From: Paul Cann
Sent: 19 June 2017 16:38
To: Planning.Responses
Subject: RE: Planning Consultation on: BE/71/17/PL

APPLICATION NO: BE/71/17/PL

Site Address: Unit 1 Railside Retail Park Shripney Road Bognor Regis PO22
9FL

Description of Works: Application for the removal of condition No. 13 imposed under planning permission BE/94/15/PL relating to the proposed surface water drainage scheme

SW PACKAGE PUMP

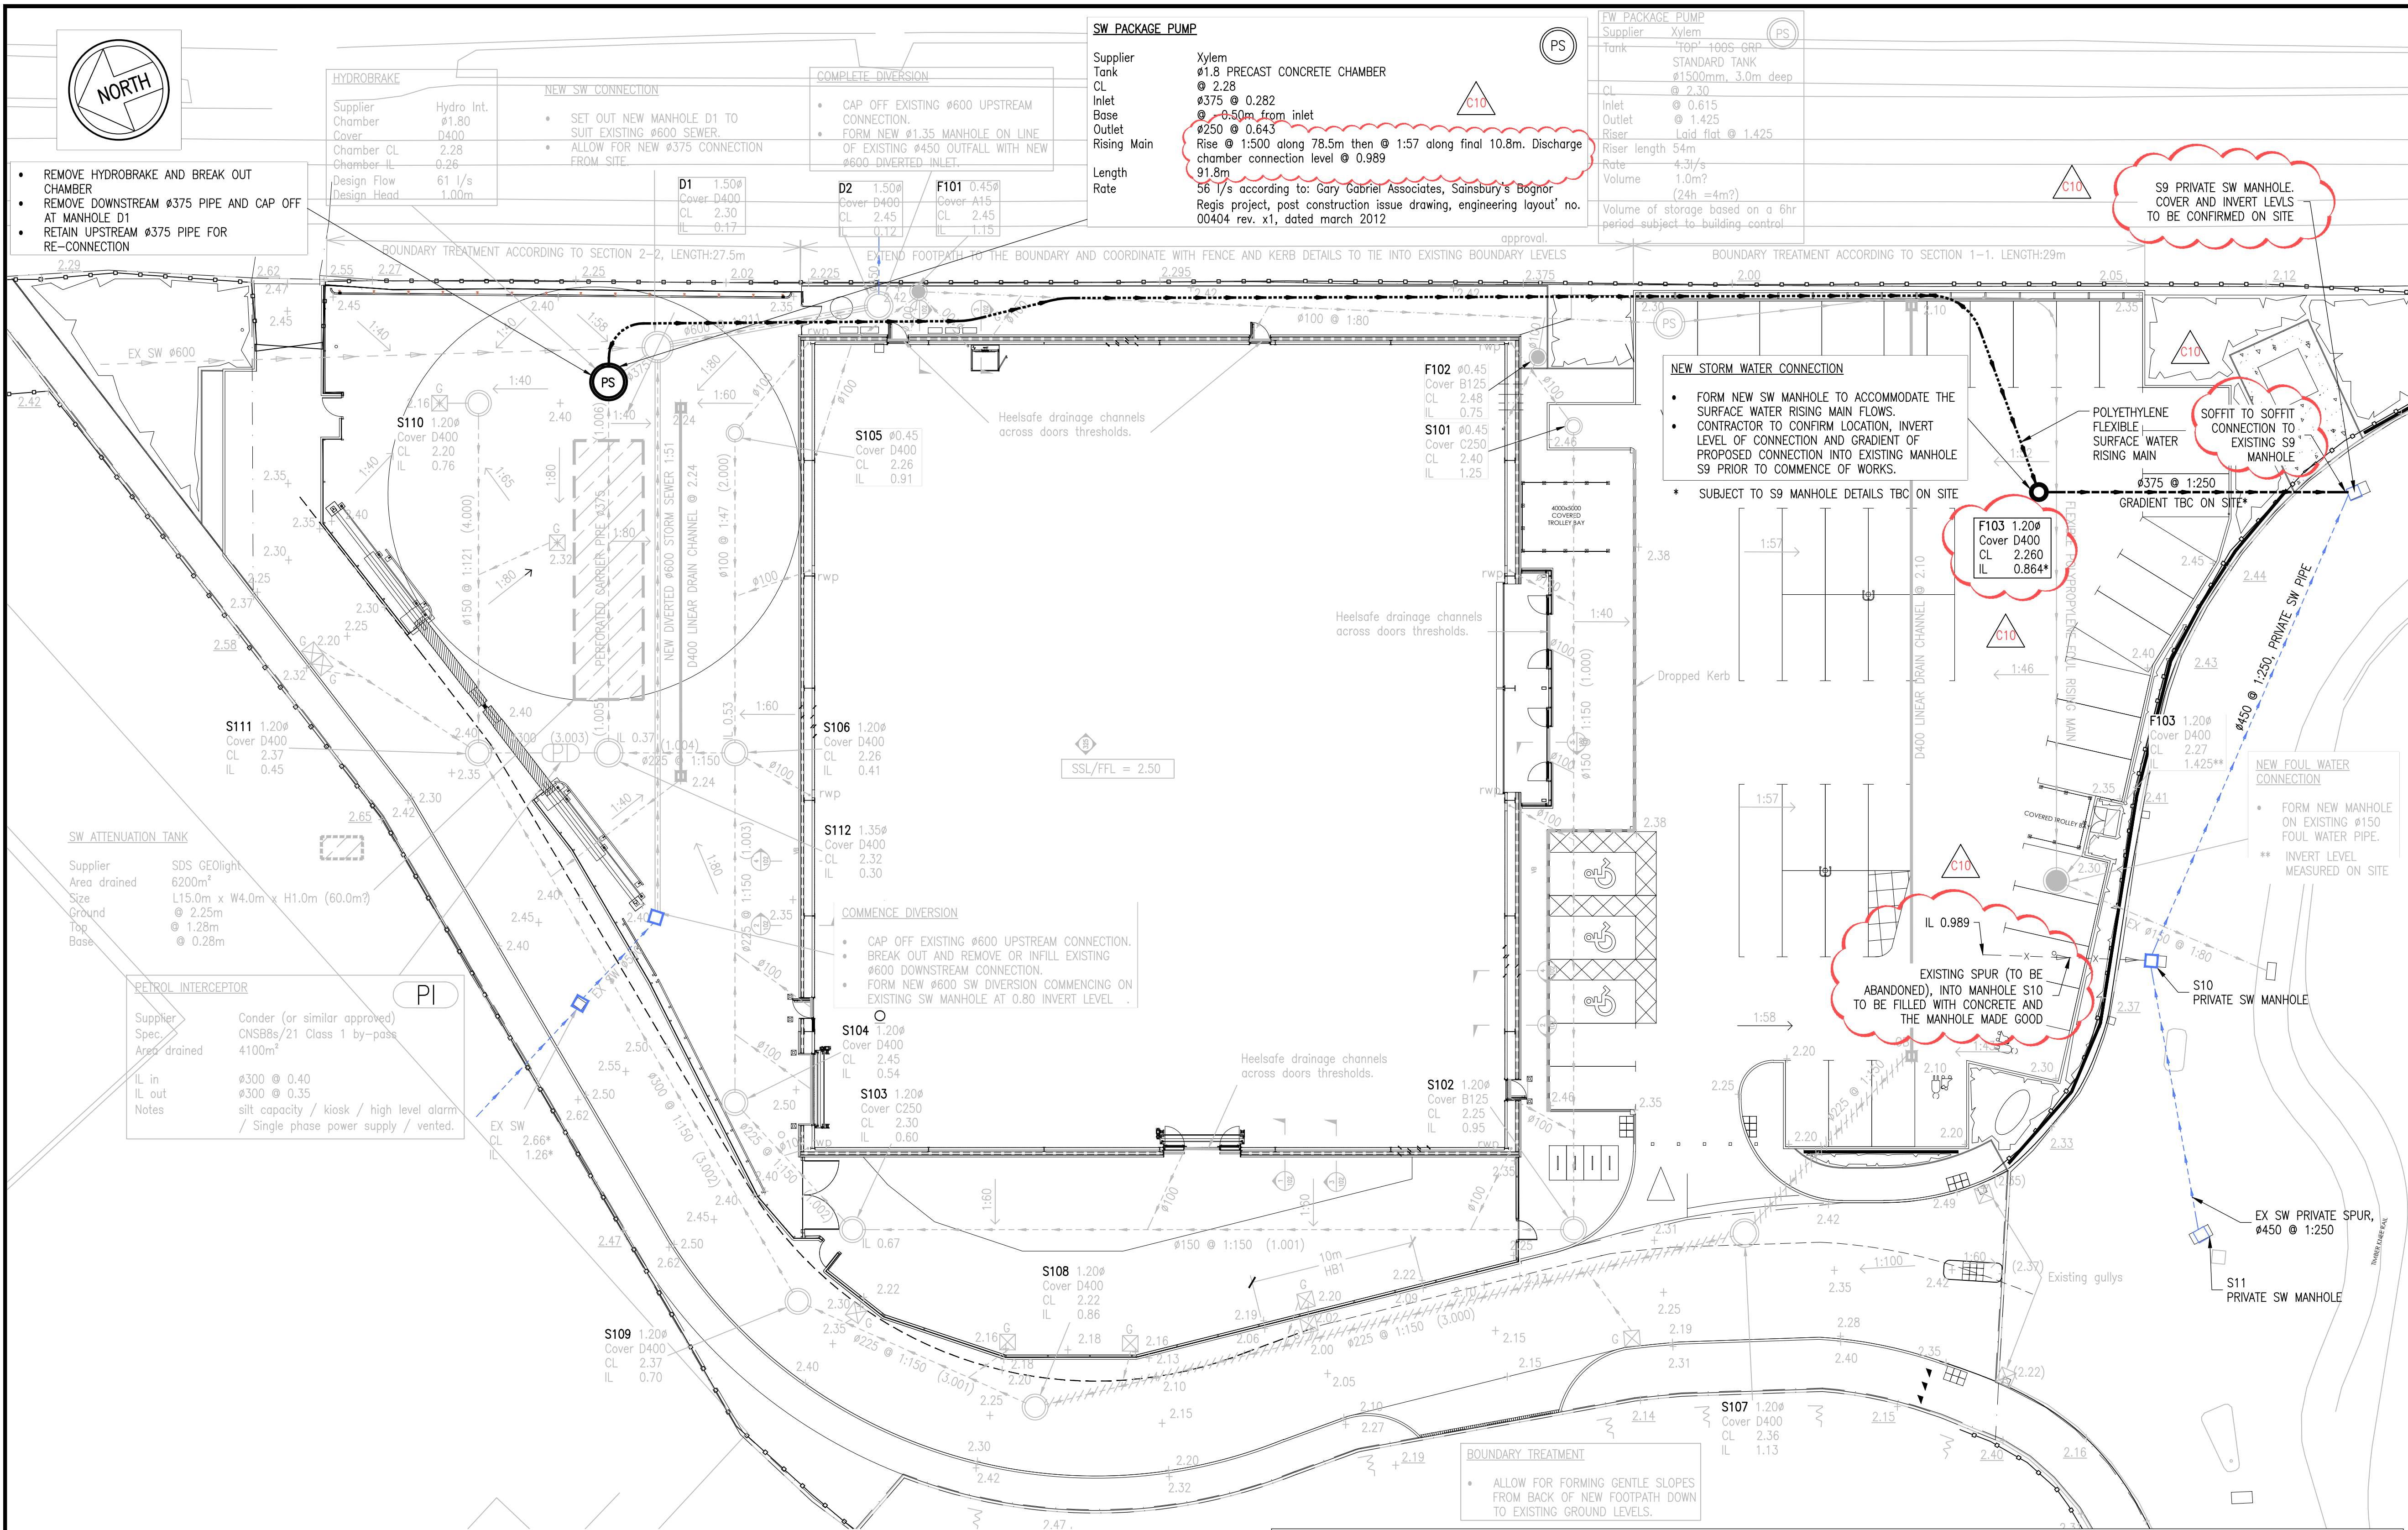
The proposal for surface water drainage disposal now incorporates a pumping station which is not a sustainable method of disposal. There appears to be no reason given as to why they are seeking to divert flows into the Sainsbury's system.

I would assume the reasons revolve around the Network Rail culvert into which the present scheme discharges. The applicant needs to provide a full explanation as to why the change is needed. We can then consider the proposals further.
